From: Maria Tomalova <Maria.Tomalova@arun.gov.uk>
Sent: Wednesday, September 13, 2023 5:59 PM
To: Planning.Responses <Planning.Responses@arun.gov.uk>
Subject: FW: Stakers Farm

Please upload the below to the applications Y/105/19 and Y/106/19: Planning Correspondence.

Subject: Stakers Farm

Drawing Title
Northern Boundary Section
Scale
1:100 @ A3

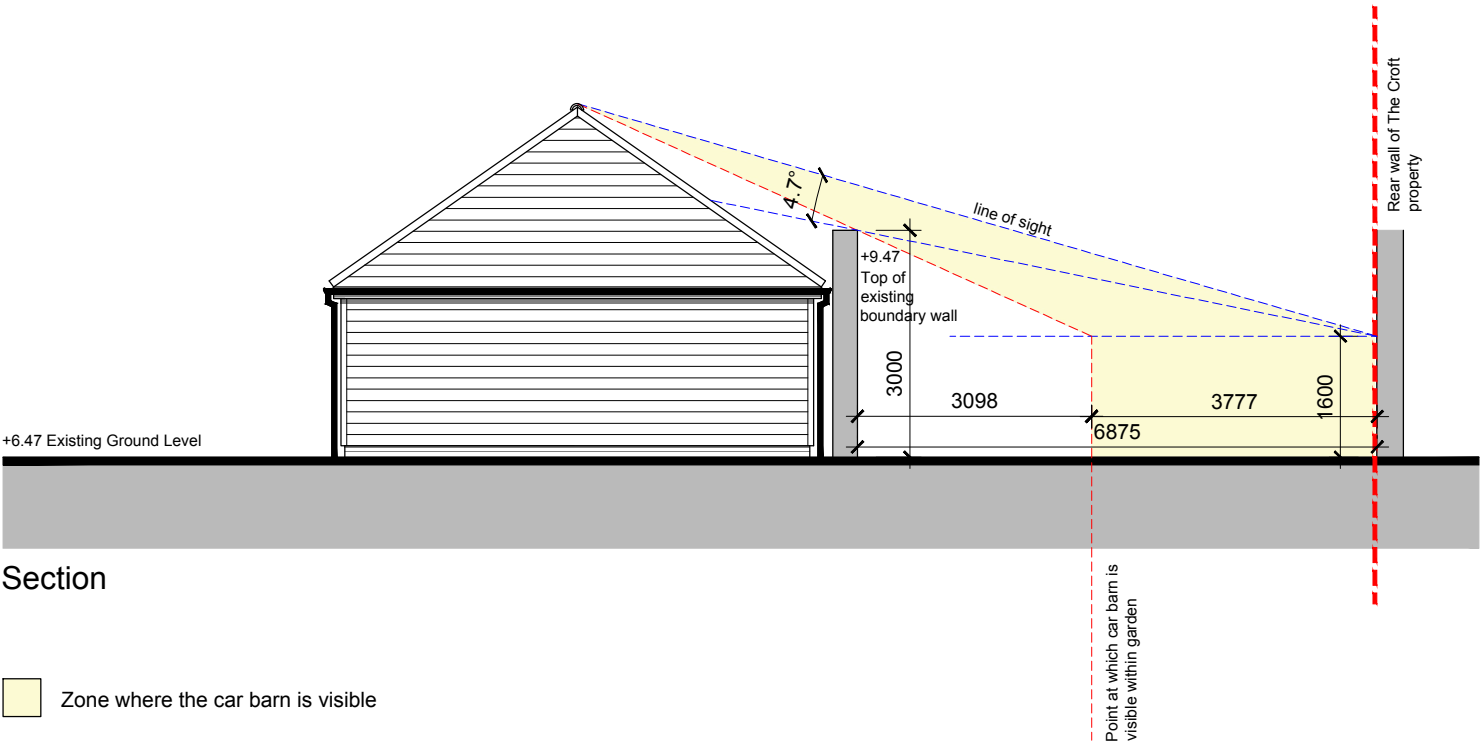
Amended drawings from my point of view (waiting for Martyn's comments)
However, the proposed Car Barn has rather prominent position and it is too dominant and even larger (southern elevation) than the barn 3 itself. It should be amended; simple structure to serve the use.

- Amendments to the site layout so that the courtyard area to the east of barns 1 and 2 is used for car parking rather than used as garden space. Courtyard forms main entrance to barns 1 and 2.
- Deletion of the proposed car barns at the north of the site and the vehicular access to these barns, and provision of amenity space for barns 1 and 2 to the rear (west).
- Proposed fencing to be 1.8m hazel hurdle fencing (specific details can be provided pursuant to a condition) – please see ground floor site plan (6797-PL-002G)
- Plans make clear that where possible, wood from existing shutters and doors will be used for new shutters.
- General note on plans regarding roof trusses being retained as a feature where possible
